**From:** Jan-Marie Lindholm <lindholm@maine.edu>  
**To:** <HCD@portlandmaine.gov>  
**CC:** Margaret Hazlett <mhazlett@fandm.edu>, Matt Thayer <mthayer777@gmail.com>  
**Date:** 2/4/2016 10:40 AM  
**Subject:** 65 Munjoy Street

Here are my concerns:

10 FIRST FLOOR & SITE PLAN
 0 4'-0" SCALE: 1/4" = 1'-0"

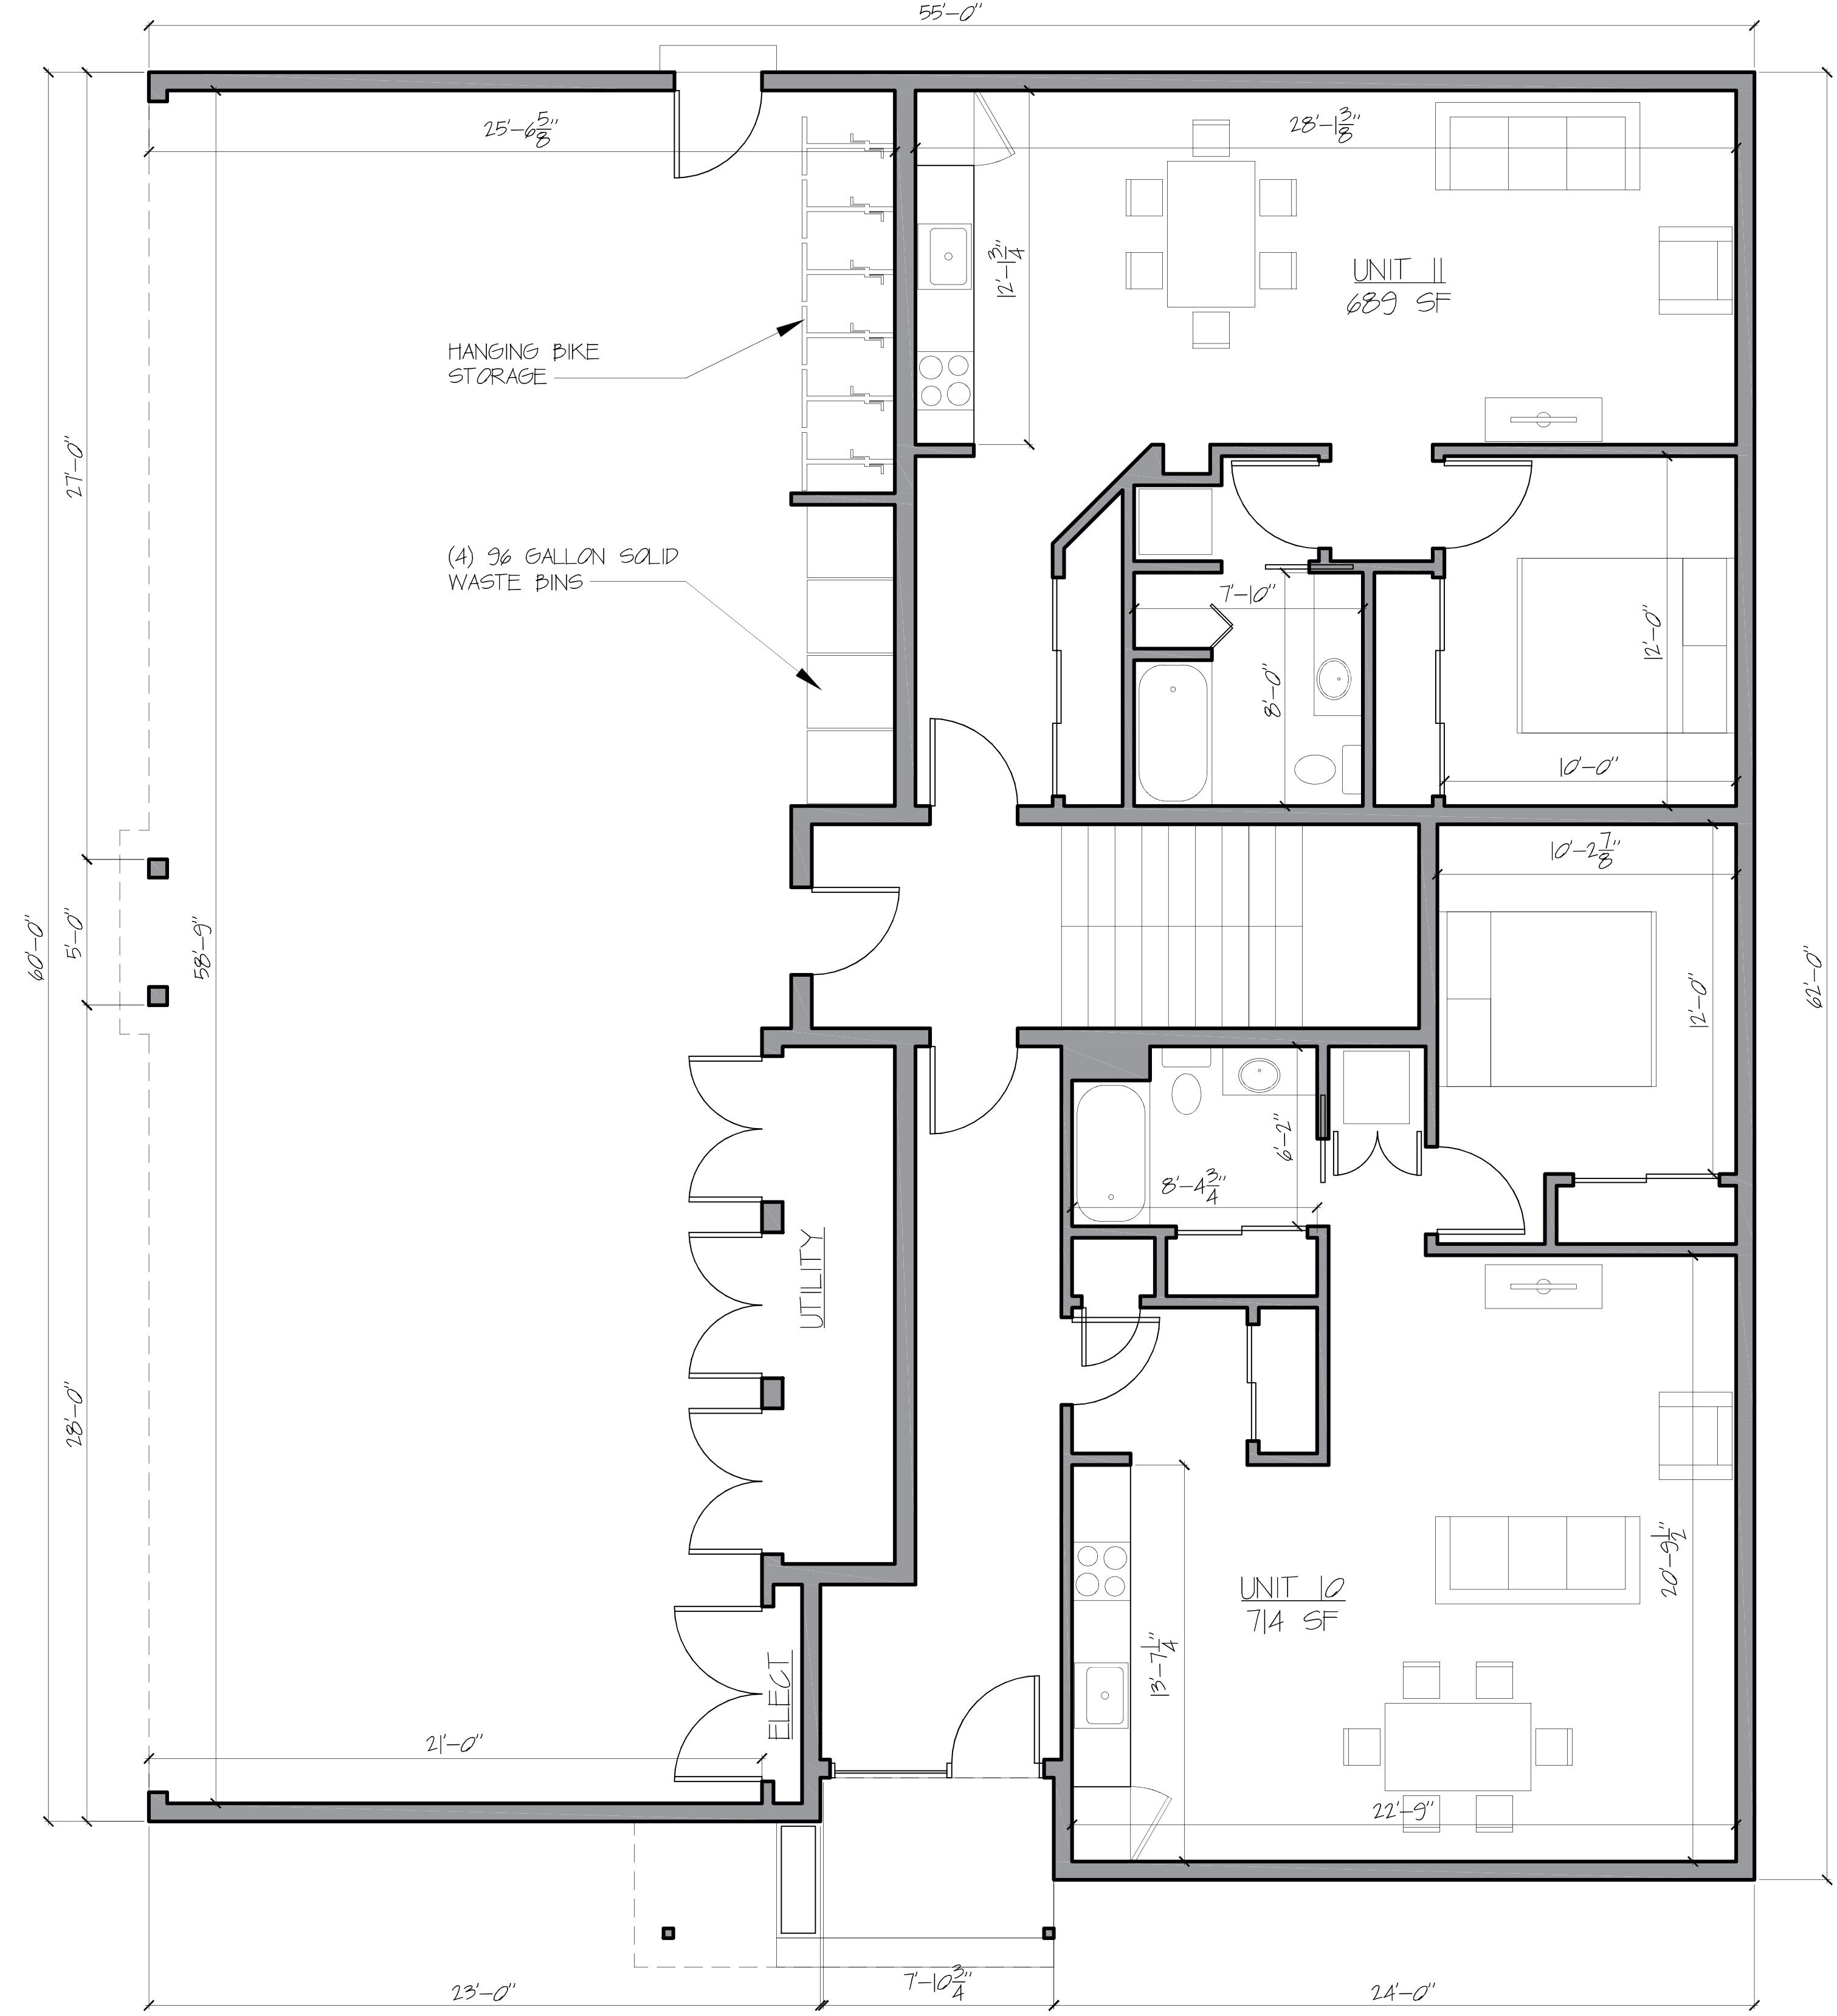
--Parking is a serious problem currently on Moody Street. By adding another 8 units with only one parking space, you are only compounding the problem. What about snow ban parking? This parking lot is utilized by the owners of 52, 54, 56, and 58 Moody and nearby neighbors that currently don't have a parking space.

FRONT ELEVATION  
0 4'-0" SCALE: 1/4" = 1'-0"

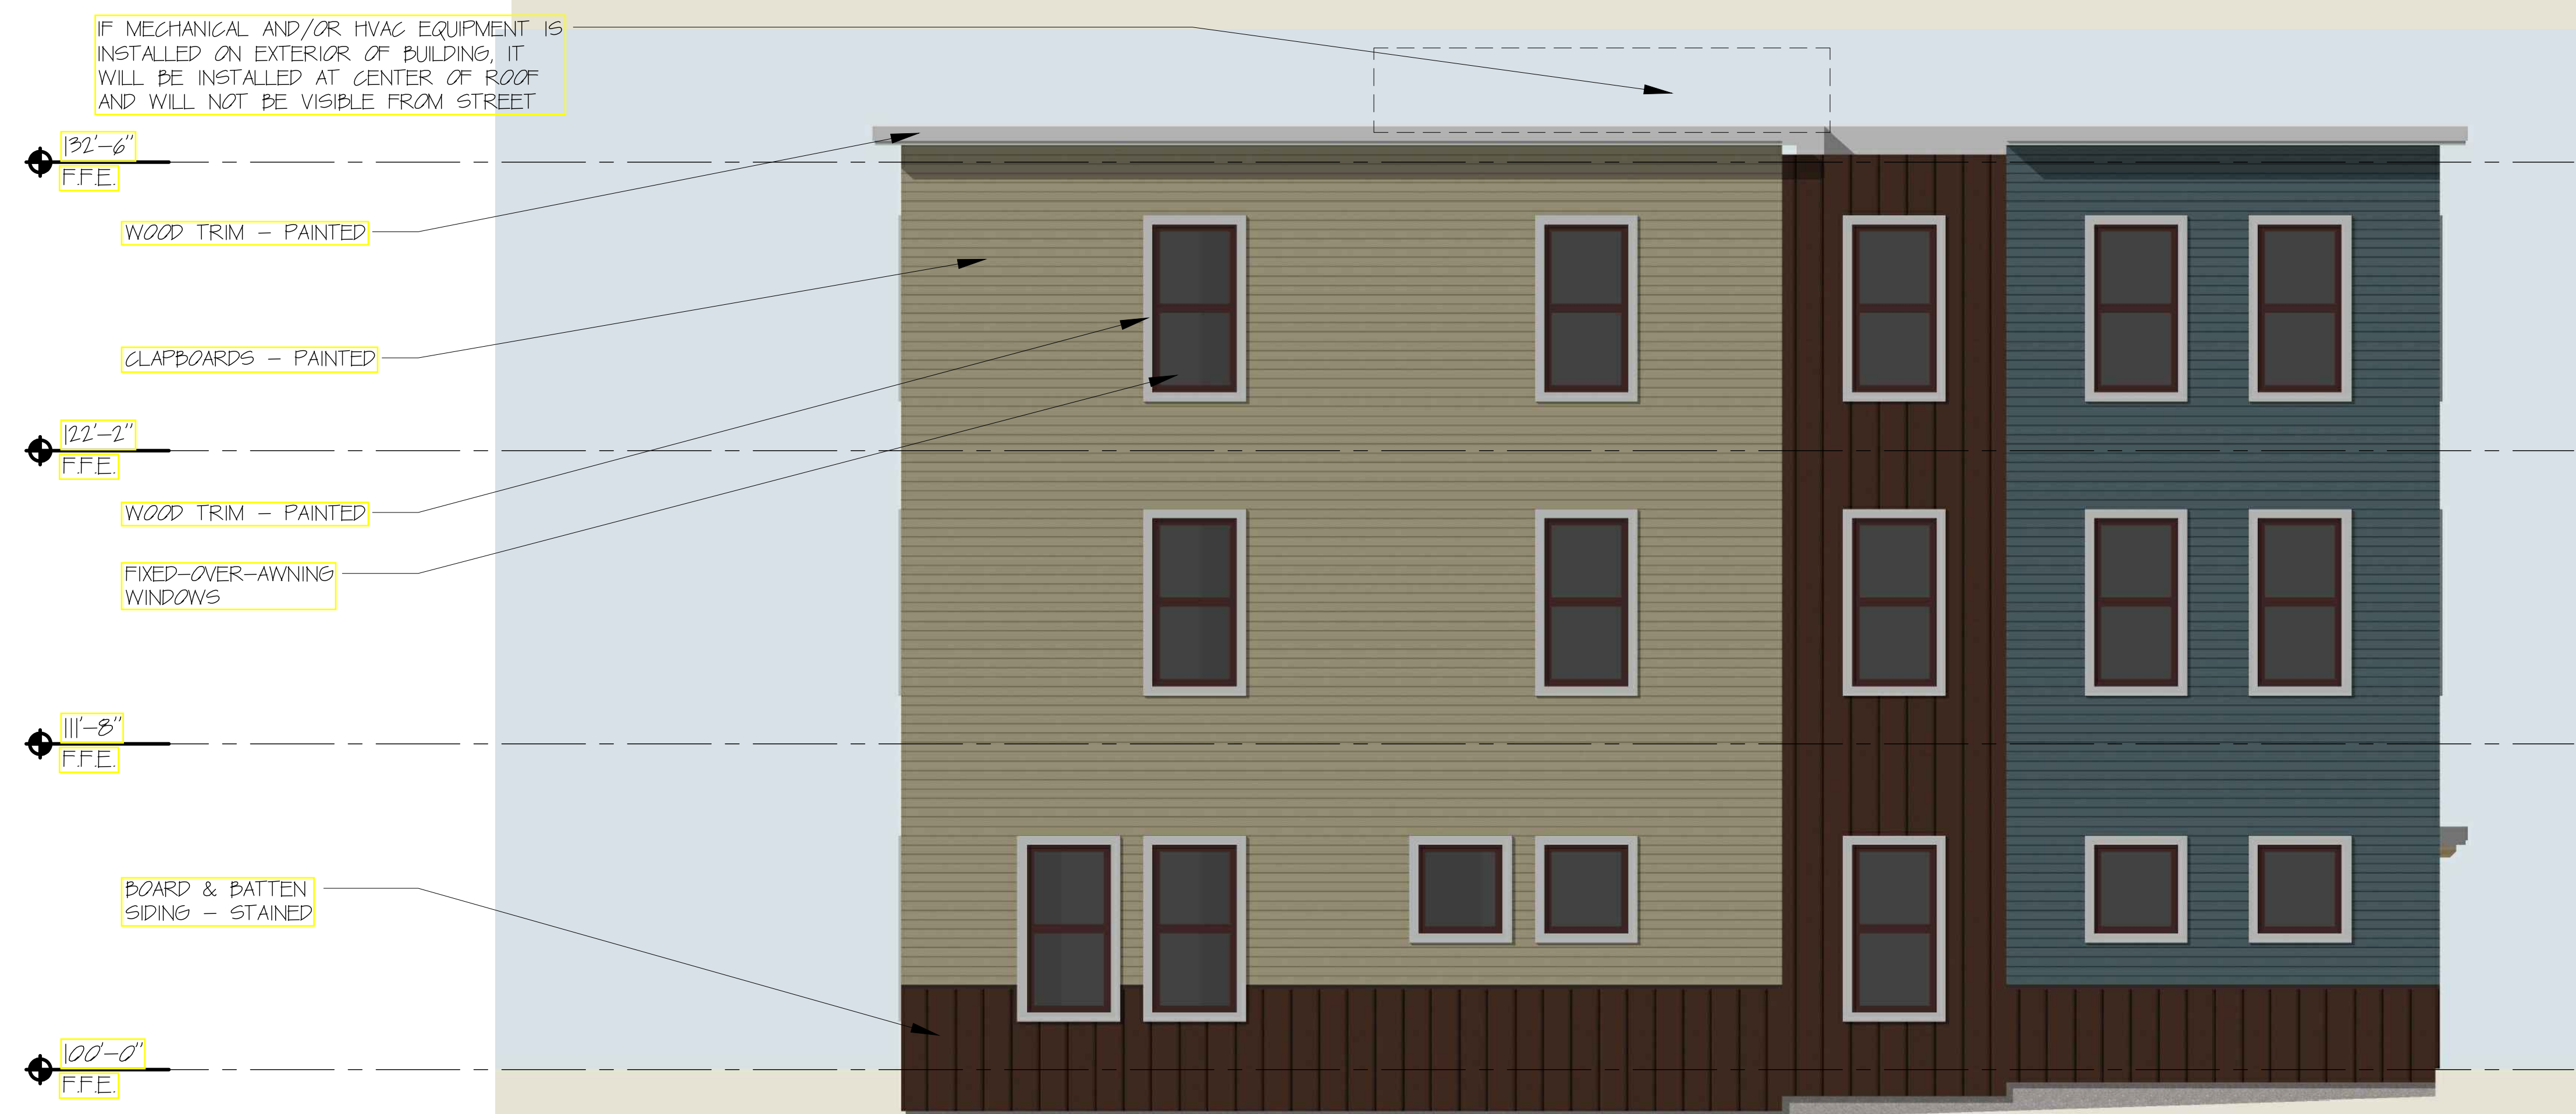
--The proposed building is 3 stories and does not fit in with the aesthetics of the neighborhood. Our building and the apartment on Wilson is only 2 stories. The building would be able to look into our windows very easily. Our privacy would be compromised.

--The building would block any light coming into our home. We have paid a lot of money for our home and now this project may cause us to move.
